Application number: 2021/90060	
What is the application for?:	Erection of take-away food outlet (within a Conservation Area)
Address of the site or building:	adj, 9, Station Road, Marsden, Huddersfield, HD7 6BS
Postcode:	HD7 5EX

Type of comment: An objection	
Do you wish your comments to be published on the website anonymously?	Yes

Proposed front elevation (1:100)

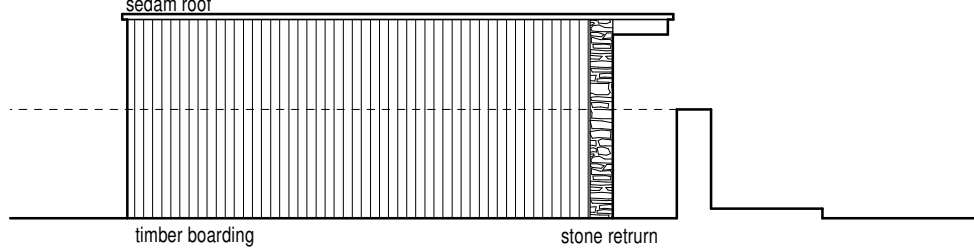
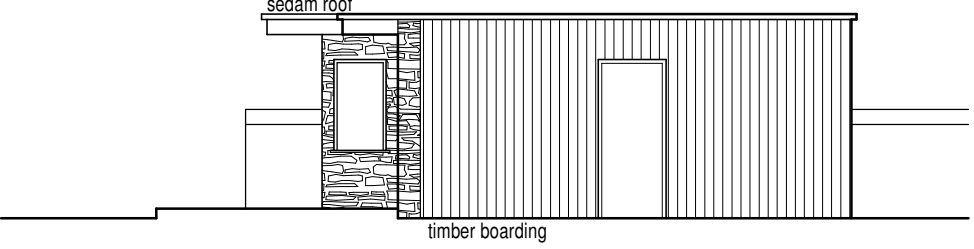
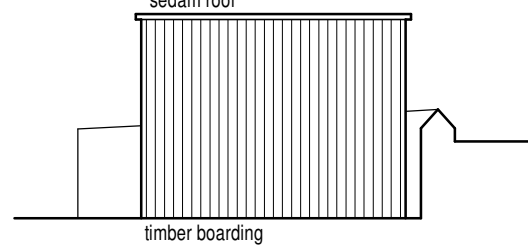
- A new infill takeaway development will not preserve or enhance the character or appearance of the conservation area, as required in the Marsden Conservation Area Appraisal and Local Plan policy LP35. The site photos included were taken a long time ago, before the Swan pub was renovated last year, and are not an accurate impression of its current state. The site has been cleared and swept and it is not an eye-sore that requires significant improvement as the photos in the application portray. The takeaway would be built with timber cladding which does not match the stone of nearby buildings. The unit would be visually striking, contrasting with existing buildings.

- The application includes no information or images as to what the takeaway would look like lit up in the evenings or dark afternoons in winter, on what is an otherwise dark street, or what the signage will be like so there is a risk this could be very inappropriate.

Proposed site plan (1:100)

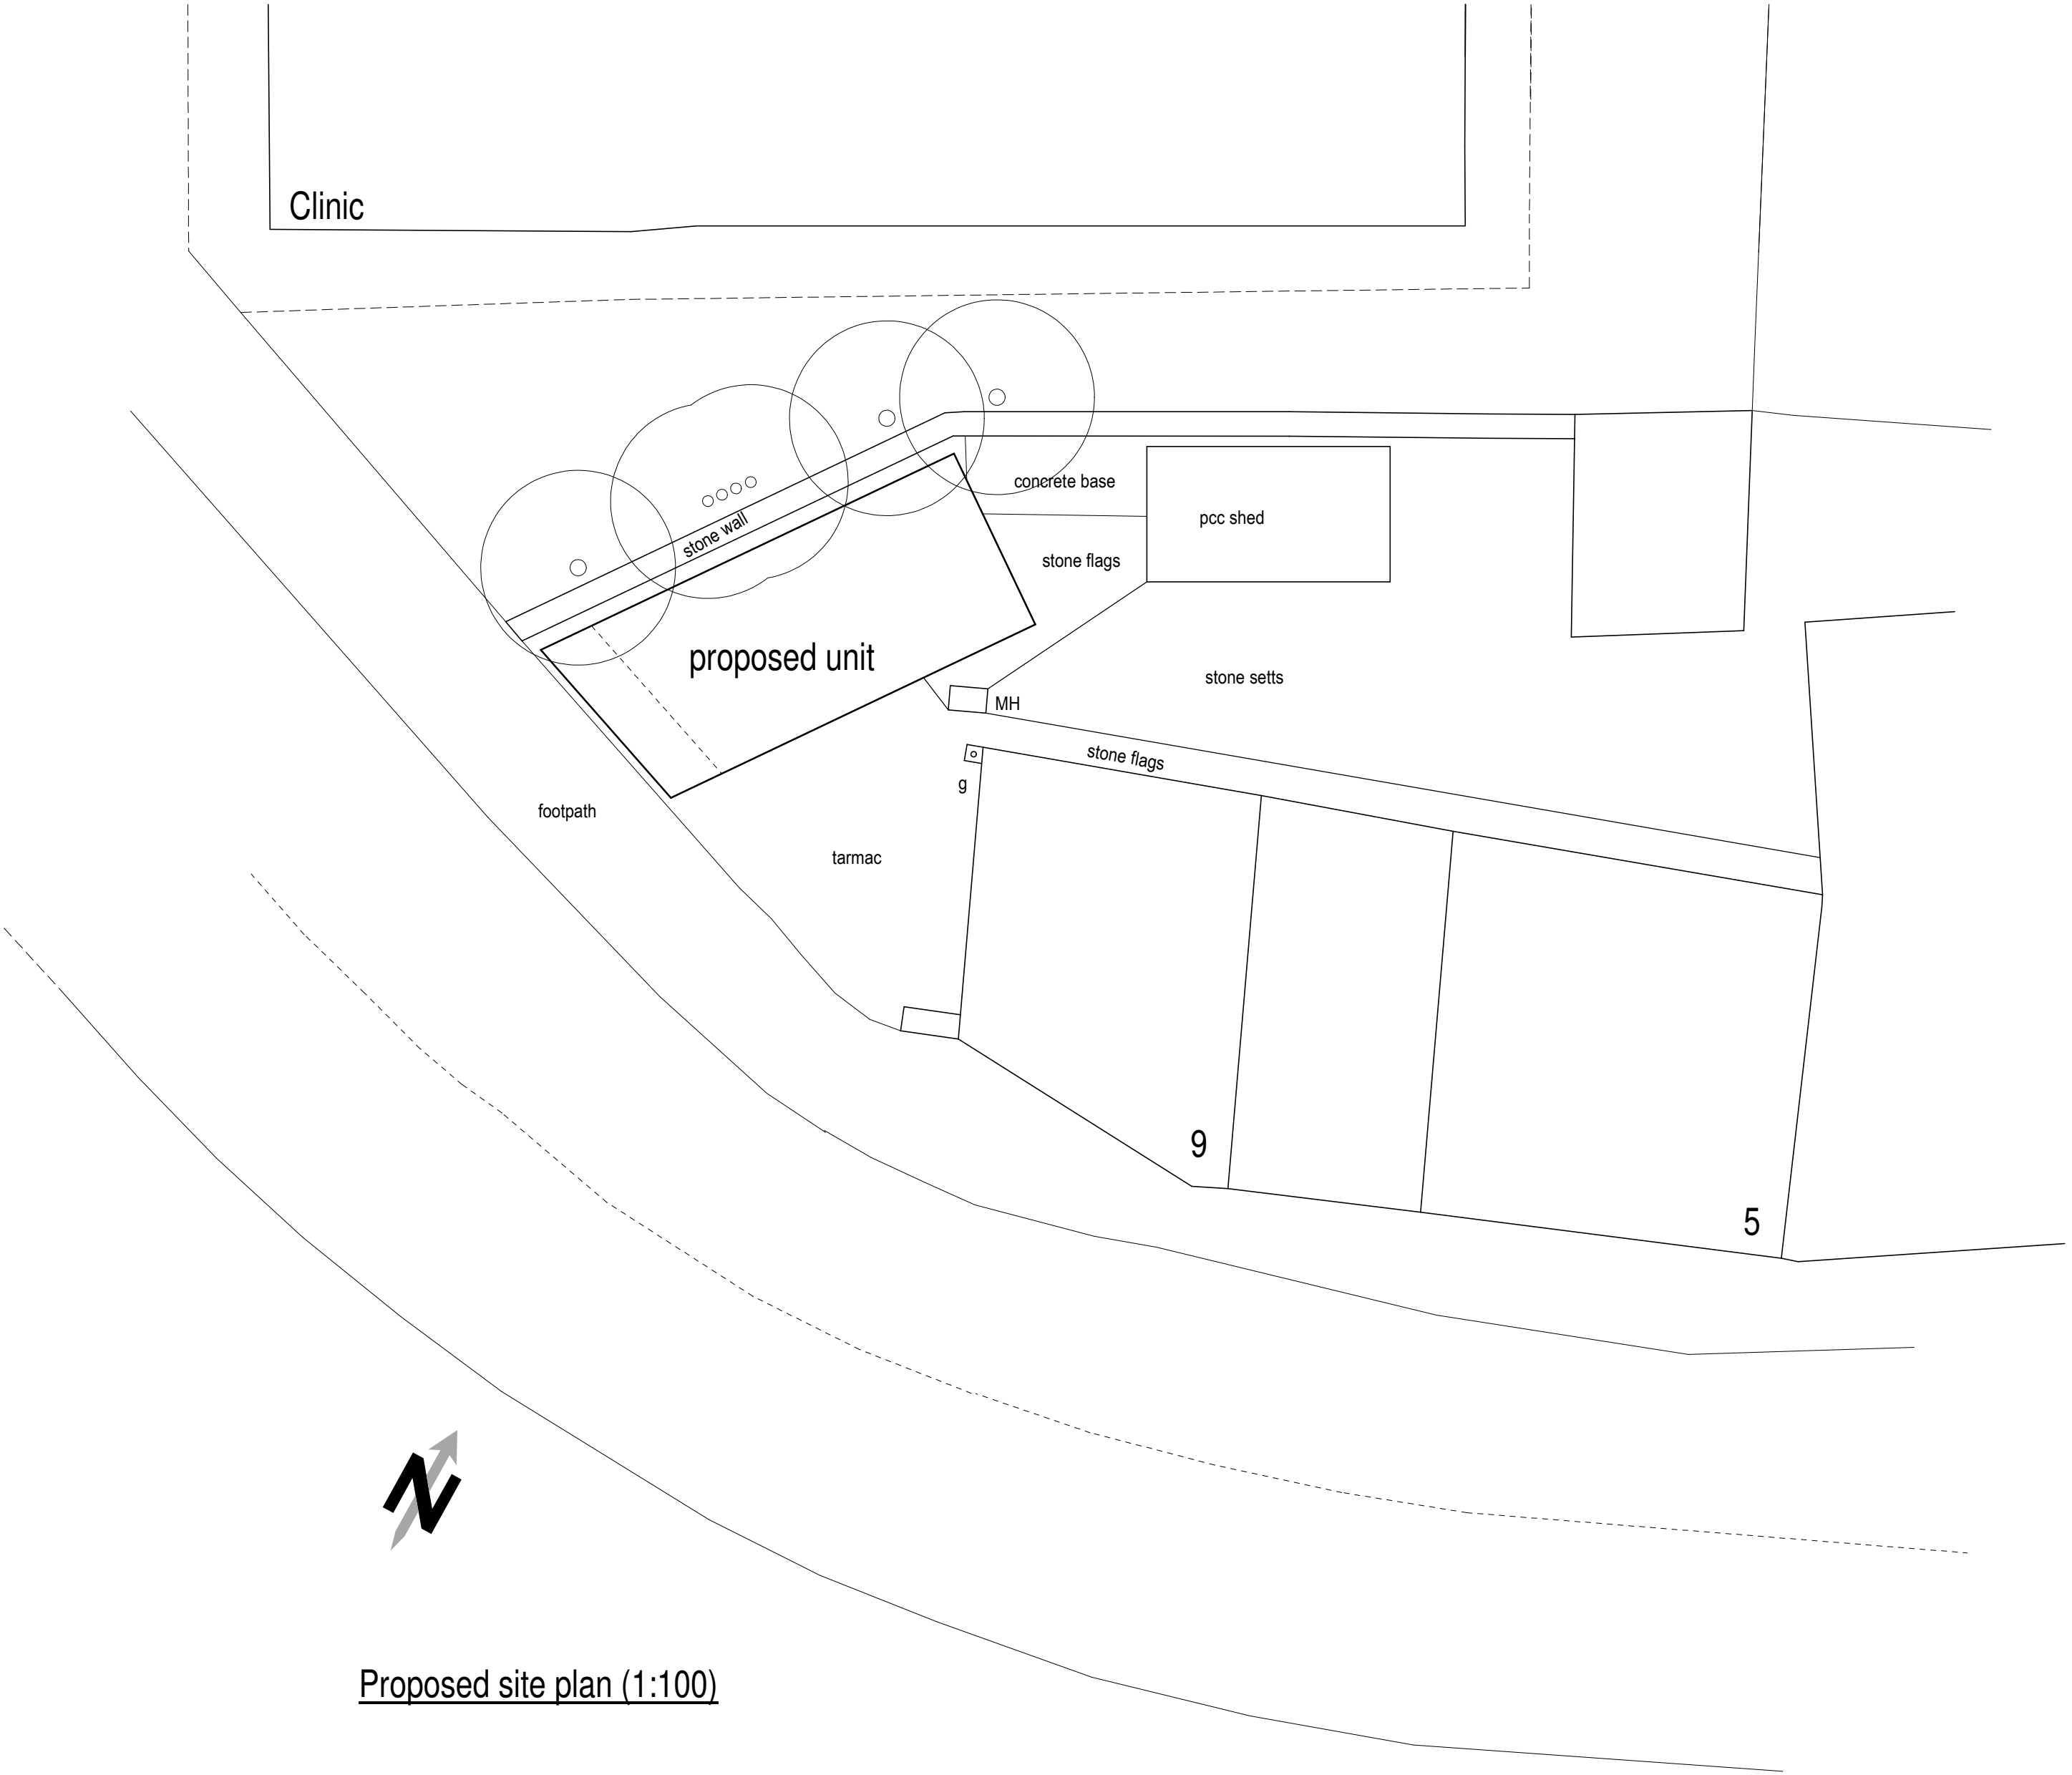
- There is no mention of providing (or emptying) any additional bins for customer's waste. Litter bins in the village are already overwhelmed on a busy weekend with visitor's takeaway waste from existing cafés etc, so it could lead to vermin.

- The site is on a blind bend road which is difficult for overtaking parked vehicles on. The proposal encourages cars to park on-street and customers would have to wait on the pavement for their orders which could force passers by into the road.
